Project Name: BEL-AIR

**CITY OF ALBUQUERQUE
PLANNING DEPARTMENT
January 30, 2008
DRB Comments**

PROJECT # 1007078 APPLICATION # 08-70044

RE: Lot 12A, Bel-Air Subdivision

Plat of
 Lot 12A, Block 20
Bel-Air

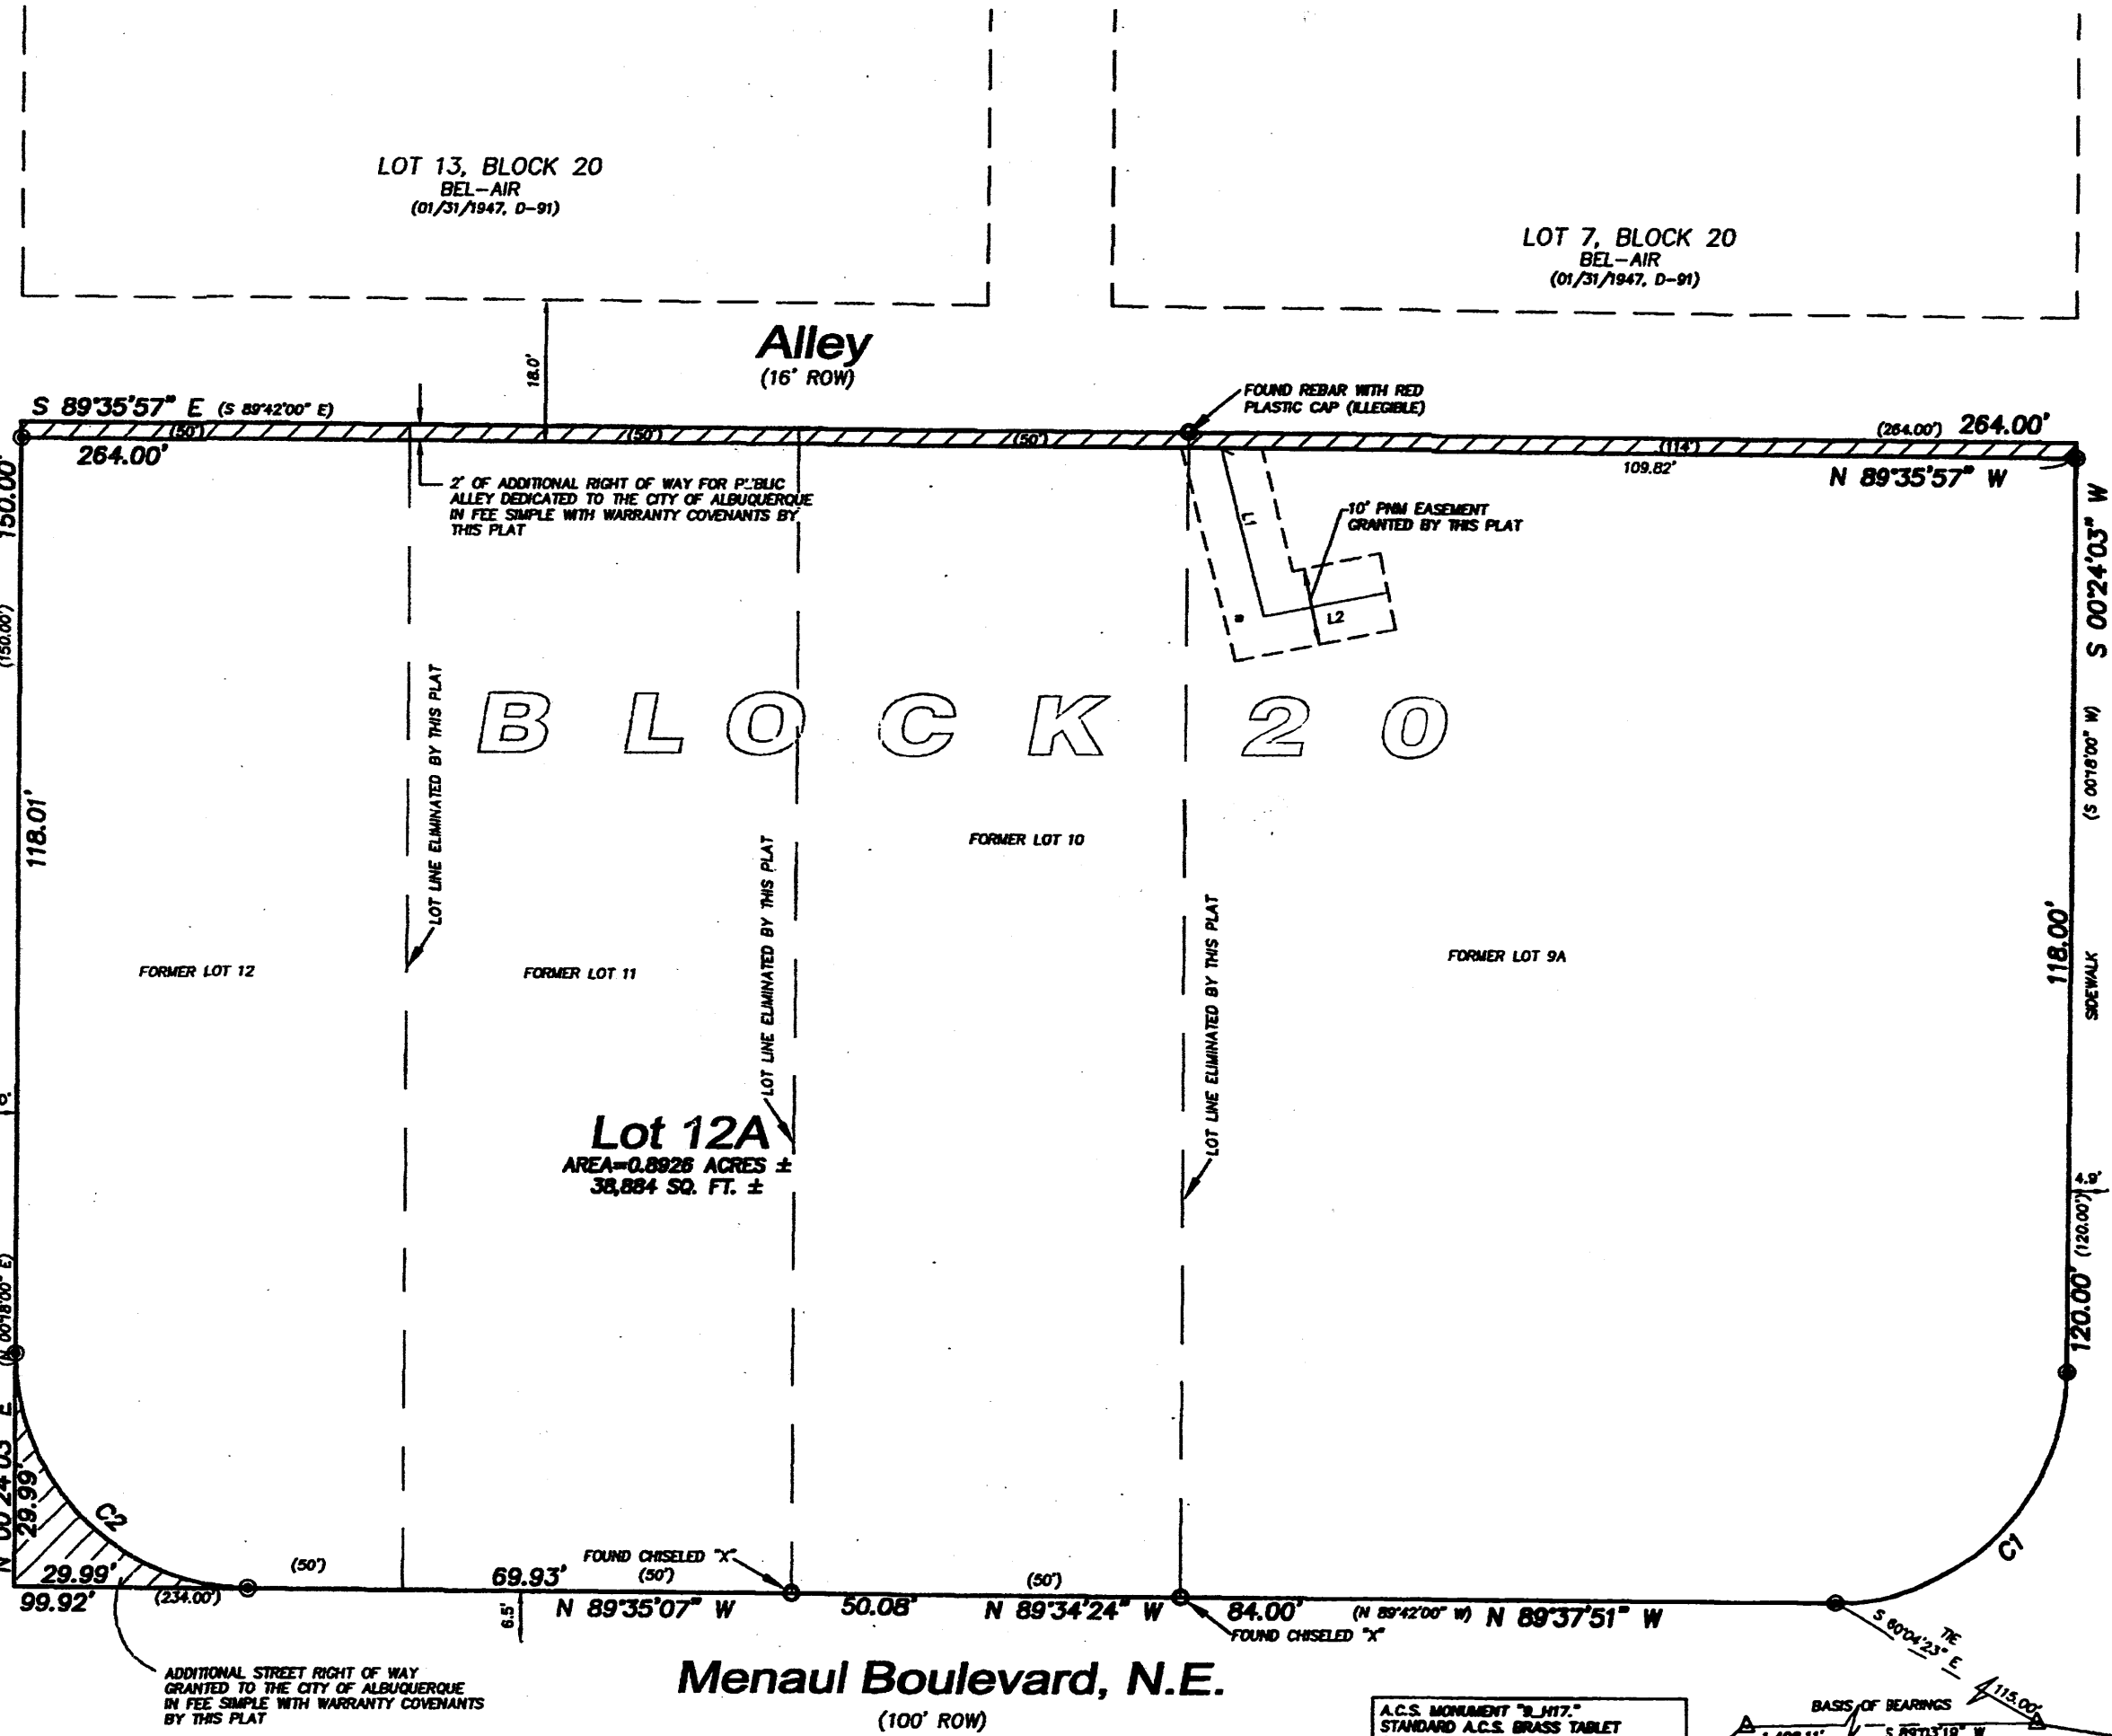
PLANNING (Last to sign): - check for 2' R-OW dedication for alley on the north

For future reference, please revise solar note to be specific to this type of request, i.e. replace the words "REQUESTED FINAL ACTION" with the word "THIS PLAT" at the beginning of the note, and delete the words "OR SITE DEVELOPMENT PLAN FOR SUBDIVISION" at the end of the note.

PRECISION SURVEYS INC agent(s) for CHU LAI YUE, TRUSTEE RVT request(s) the above action(s) for all or a portion of Lot(s) 9A, 10 - 12, Block 20, **BEL-AIR**, zoned C-2, located on MENAUL BLVD NE BETWEEN MONROE NE AND MADISON NE containing approximately 0.9048 acre(s). (H-17)
THE PRELIMINARY/FINAL PLAT WAS APPROVED WITH FINAL SIGN OFF DELEGATED TO PLANNING FOR 2 FT DEDICATION FOR ALLEY RIGHT OF WAY ON THE NORTH.
